**Addendum No. 1**

RE: Contract ID C203146

**Cabarrus County (P-5208D)**

SR-1304 Extension (Roberta Road) Grade Separation Over Norfolk Southern/NCRR  
Railroad From SR-1161 To NC-49 In Harrisburg

PROJECT REFERENCE NO. P-5208D	SHEET NO. RR-2D
R/W SHEET NO.	HYDRAULICS ENGINEER
RAILROAD DESIGN ENGINEER	ENGINEER

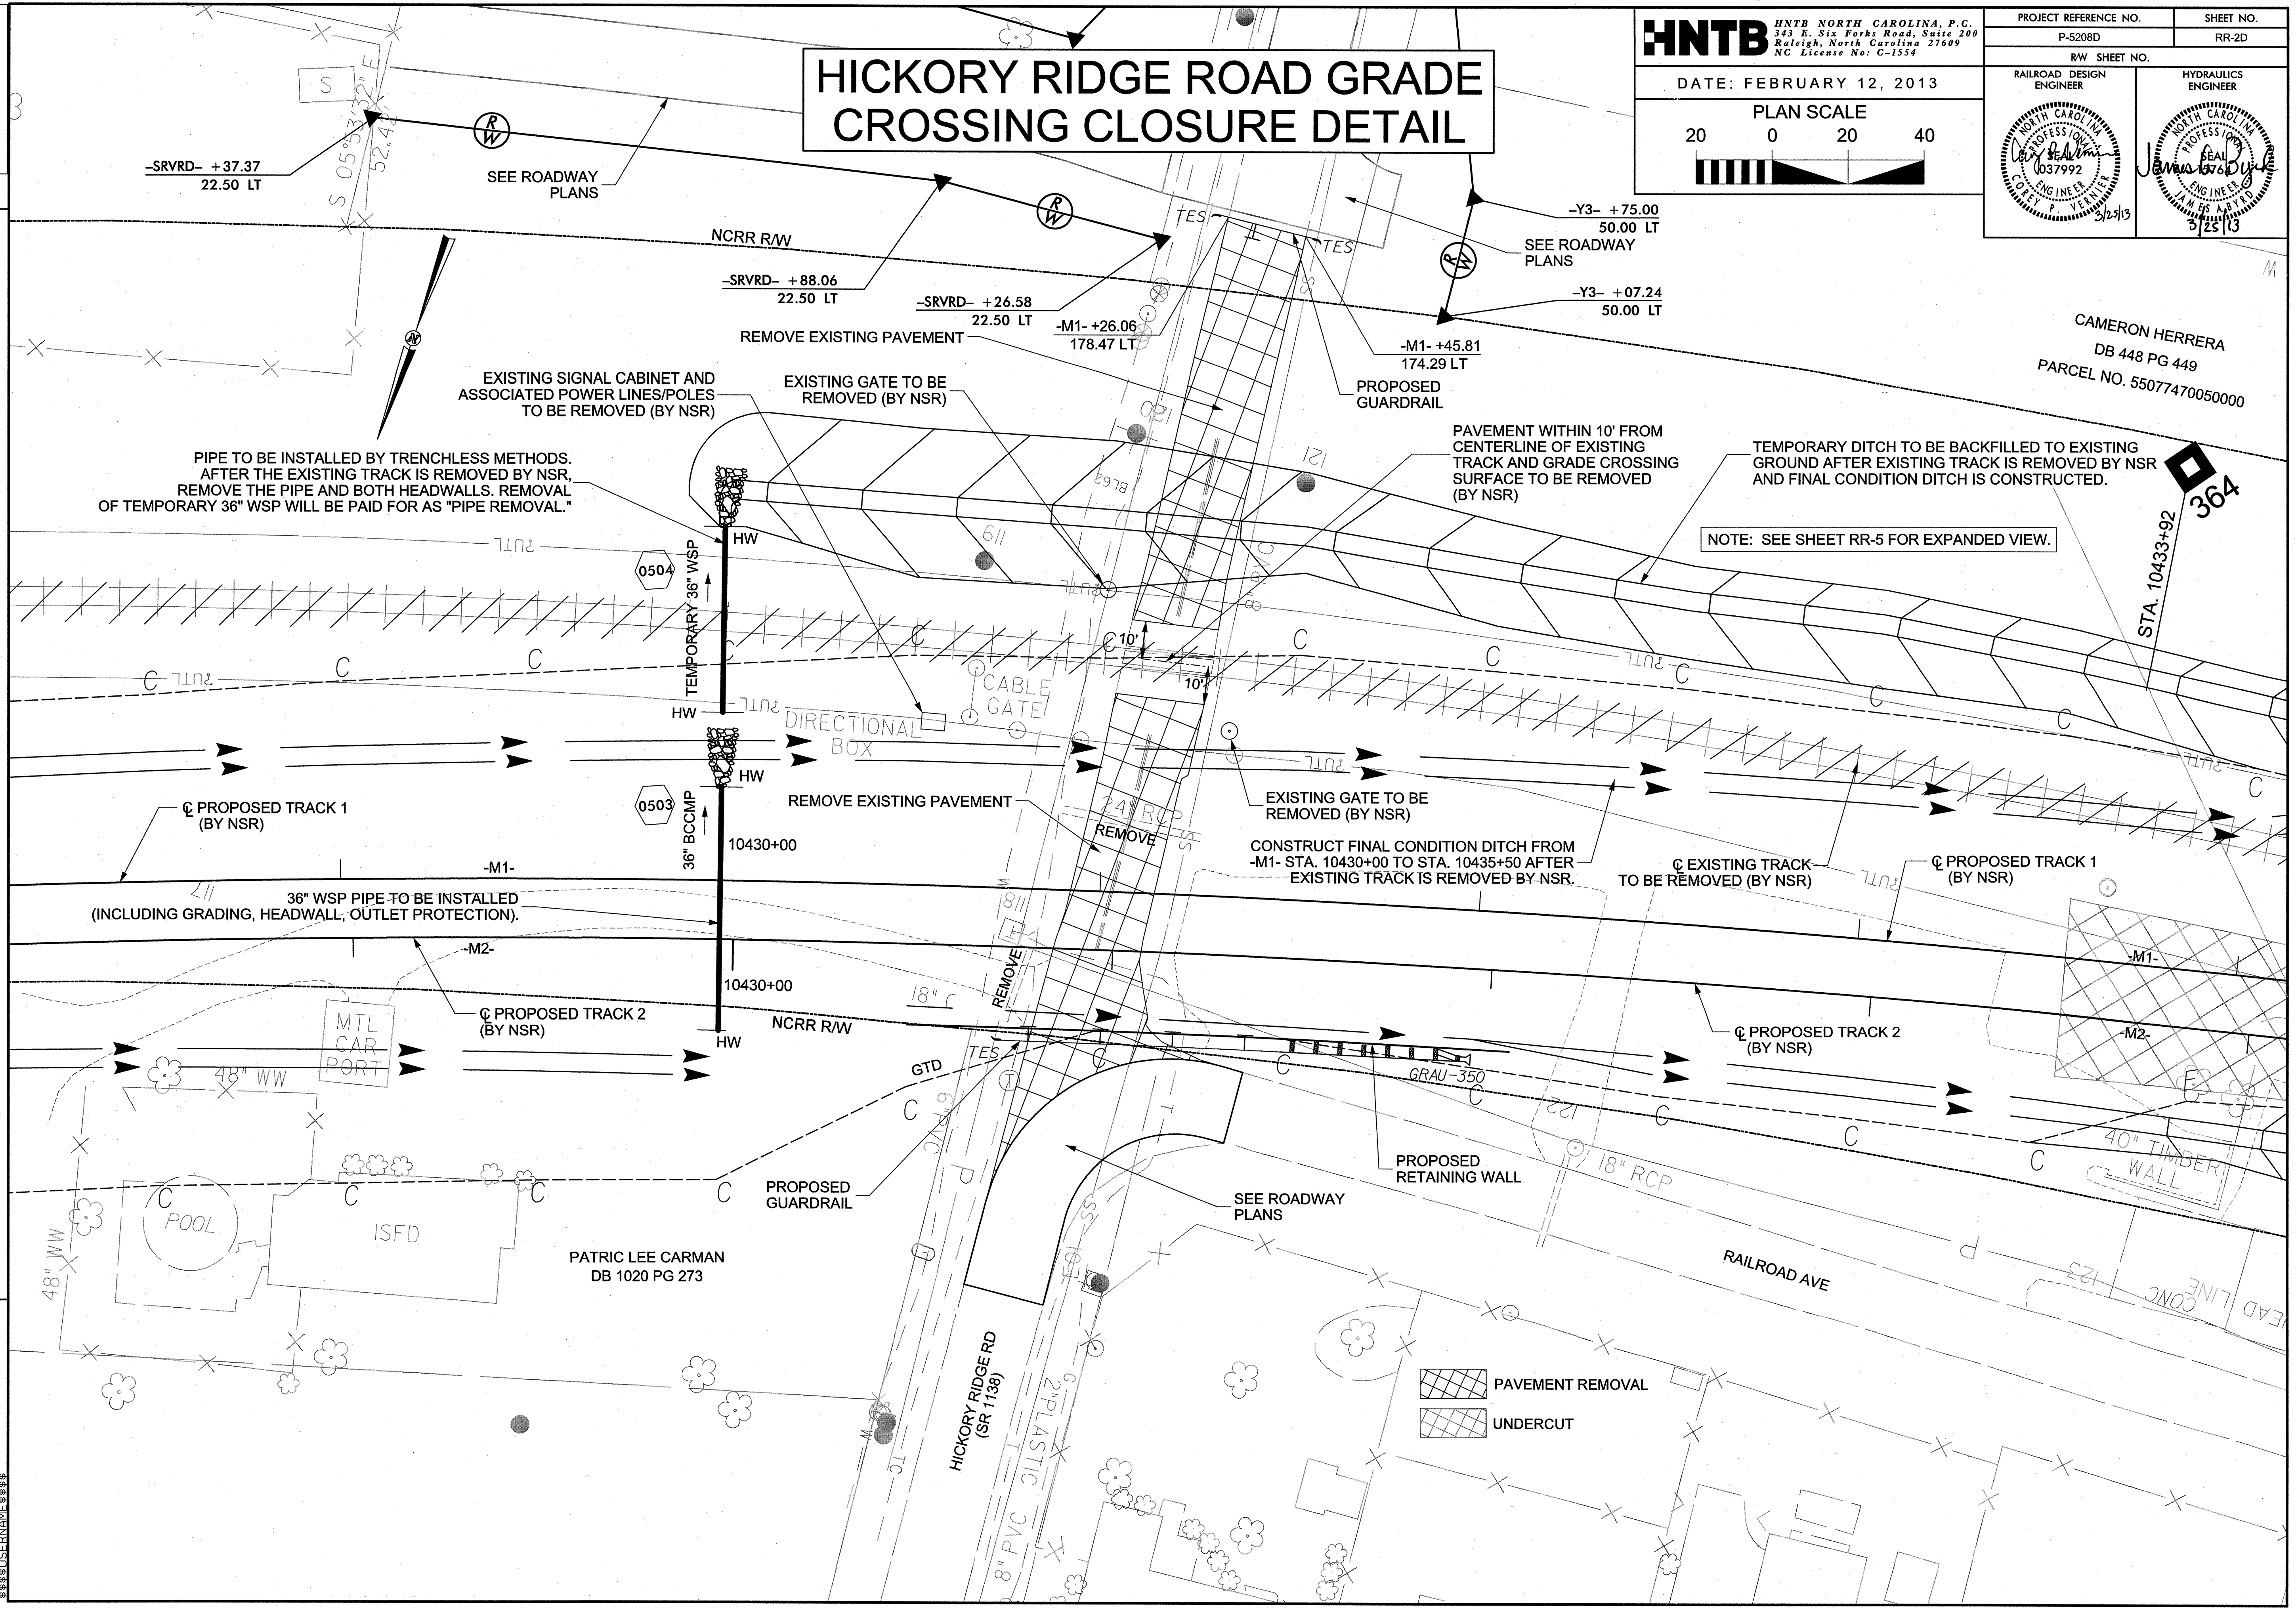
Sheet Nos. RR-2, RR-2A, RR-2D, RR-2E, RR-4 thru RR-6, EC-11, EC-12, EC14 thru EC-16 have been revised as a result of a change of location of a drainage pipe under the railroad and other ditch related changes. Please void Sheet Nos. RR-2, RR-2A, RR-2D, RR-2E, RR-4 thru RR-6, EC-11, EC-12, EC14 thru EC-16 in your plans and staple the revised Sheet Nos. RR-2, RR-2A, RR-2D, RR-2E, RR-4 thru RR-6, EC-11, EC-12, EC14 thru EC-16 thereto.
